# CITY OF ALBUQUERQUE

April 19, 2016

**Re: Advanced Auto Parts  
2807 San Mateo Blvd., NE  
30-Day Temporary Certificate of Occupancy- Transportation Development  
Engineer's/Architect's Stamp dated 8-7-15 (H17-D111)  
Certification dated 4-8-16**

TRAFFIC CIRCULATION LAYOUT

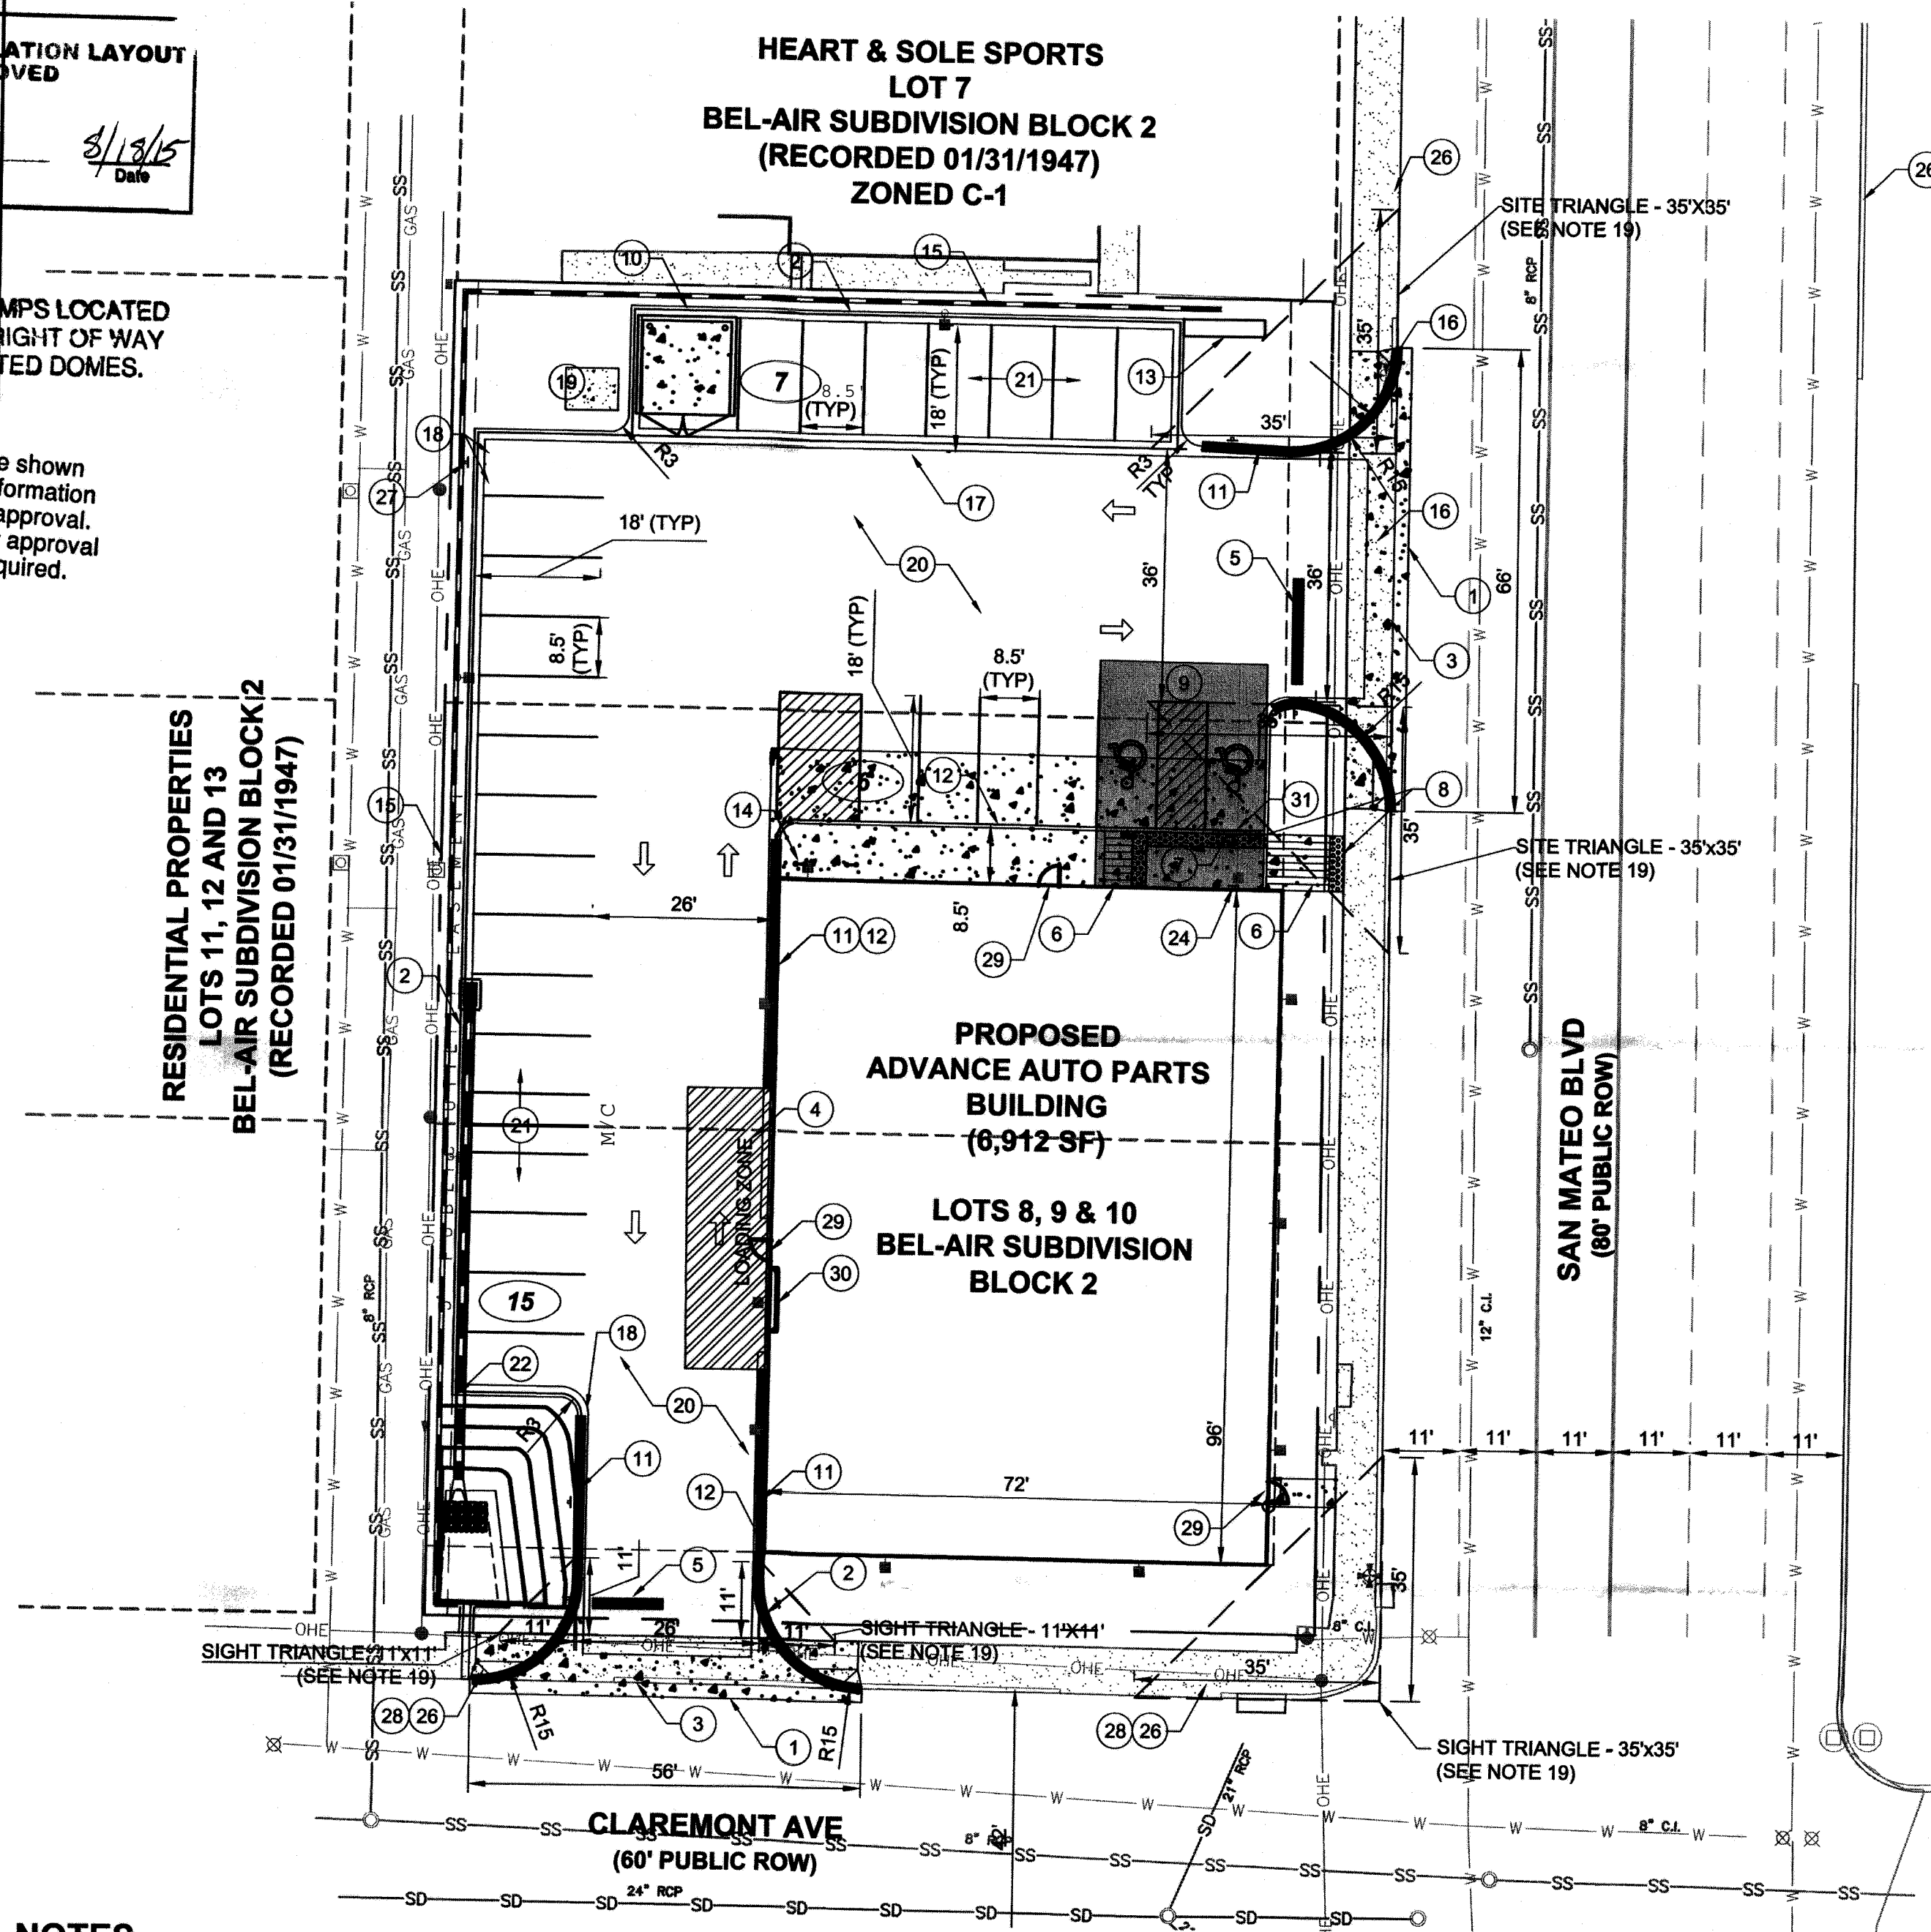
- Correction of Truncated domes at the intersection of Claremont Ave. and San Mateo Blvd.
